From:
Sent: 05 September 2026 09:48
To: DC Admin
Subject: Re: Objection to Planning Application 2026/62/91926/E - 158 Hawthorne Way Shelley
Attachments: filedownload.pdf; filedownload (1).pdf

I am writing further to my objection to the above planning application, to submit supplementary evidence in support of the points I raised regarding parking provision and highway/service strip ownership.

Proposed Site Layout
Scale 1:250

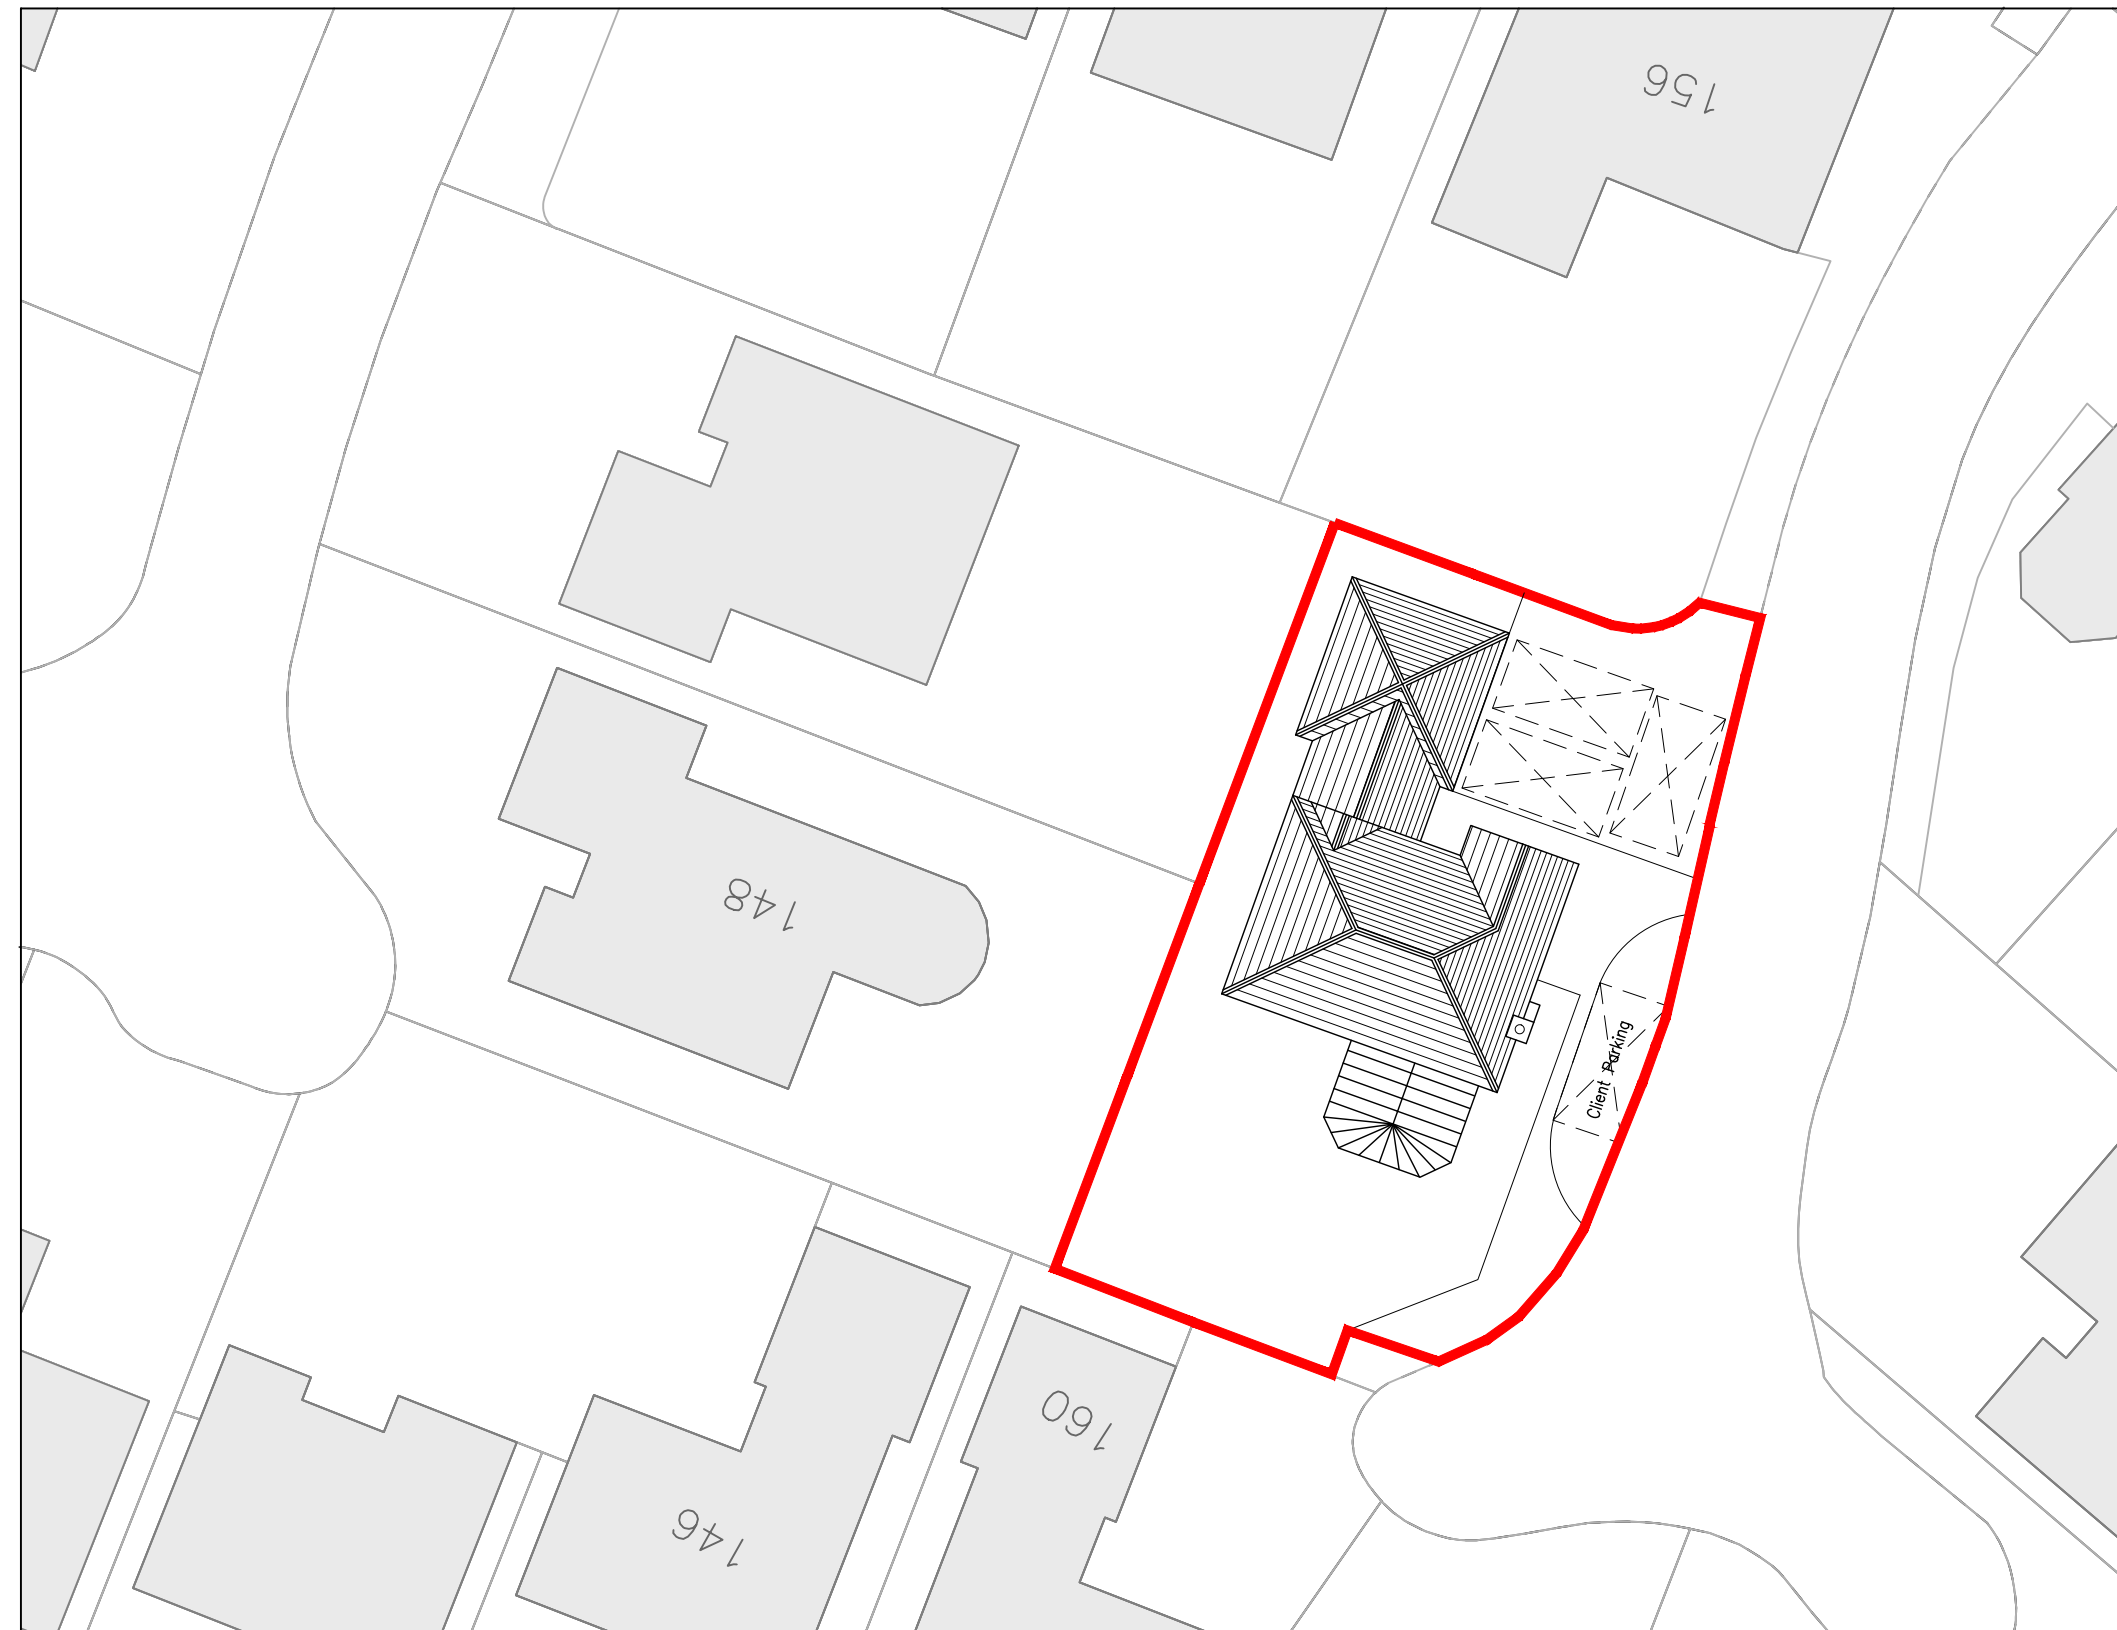
I raise this because it directly corroborates the point I have already made in my objection: that the parking area and service strip shown in brown, green and yellow on the current application's plans (attached, edged in the top right of the lower street) are not privately owned by the applicant but form part of the adopted highway, including the same type of 1.8m service margin referenced in the Highways response above.

If the same rule applied to 156 Hawthorne Way, it should apply equally here, and I would ask that Highways be asked to confirm the ownership and status of this land in the same way before any decision is made.
